SCOPING OPINION:

Proposed Immingham Eastern Ro-Ro Terminal

Case Reference: TR030007

October 2021

Figure 2 – Port of Immingham Plan

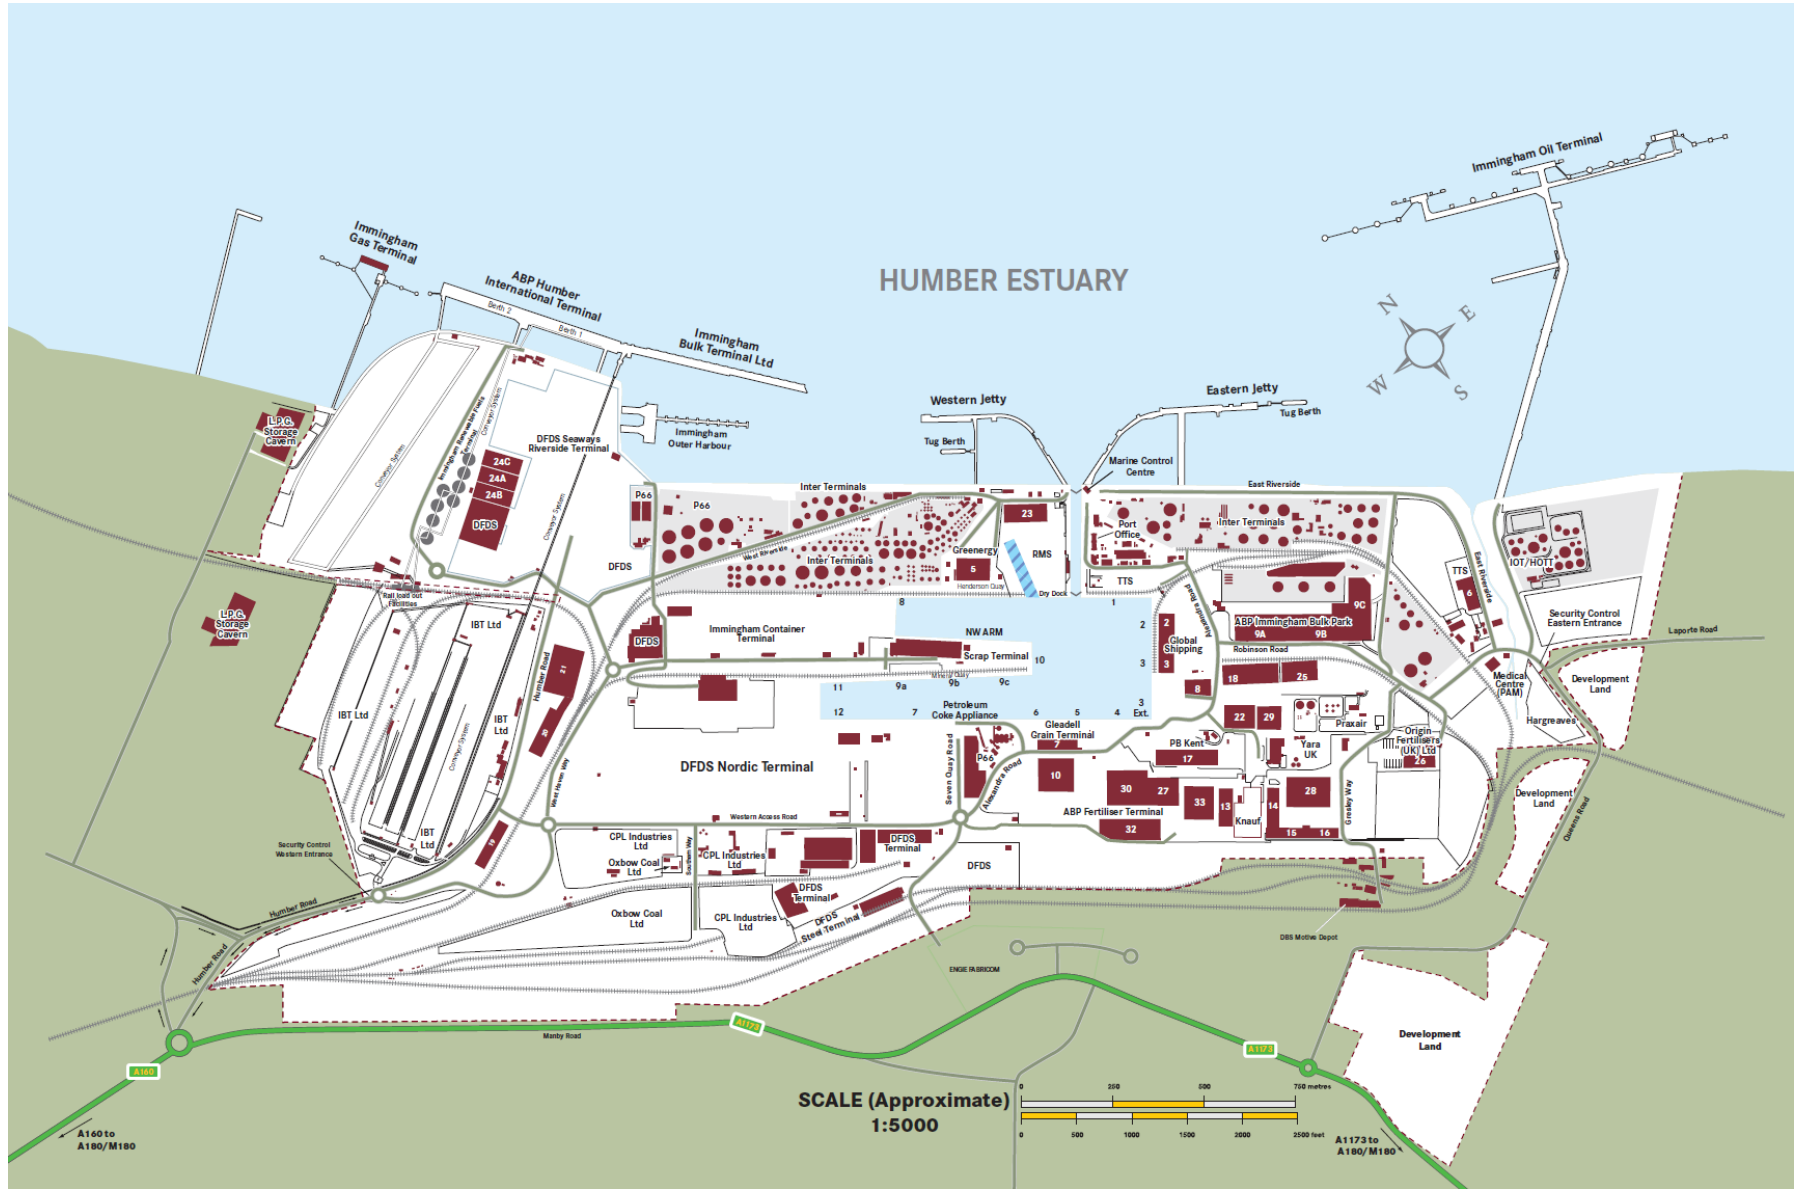
- 2.2.4 Figure 2 shows the location and dimensions of the structures proposed for the marine environment. These comprise an approach jetty from the shore, a linkspan (link bridge), two floating pontoons and two separate finger piers with two berths each (one on each side of the piers to create four berths). The stern ramps of the ships using the facility would rest on the two floating pontoons.

- diagram(s) which provide clearly labelled locations for the various structures proposed for the marine environment which are included in the Project Description; and

- 2.3.2 The Scoping Report provides dimensions for the structures in the marine environment but includes limited information on the location and dimensions of the landside structures. This information should be provided in the project description in the ES. If these points have not confirmed the ES should clearly explain the assumptions used to provide a robust assessment of the Proposed Development's effects on the environment. The Applicant's attention is drawn to the section on flexibility below.
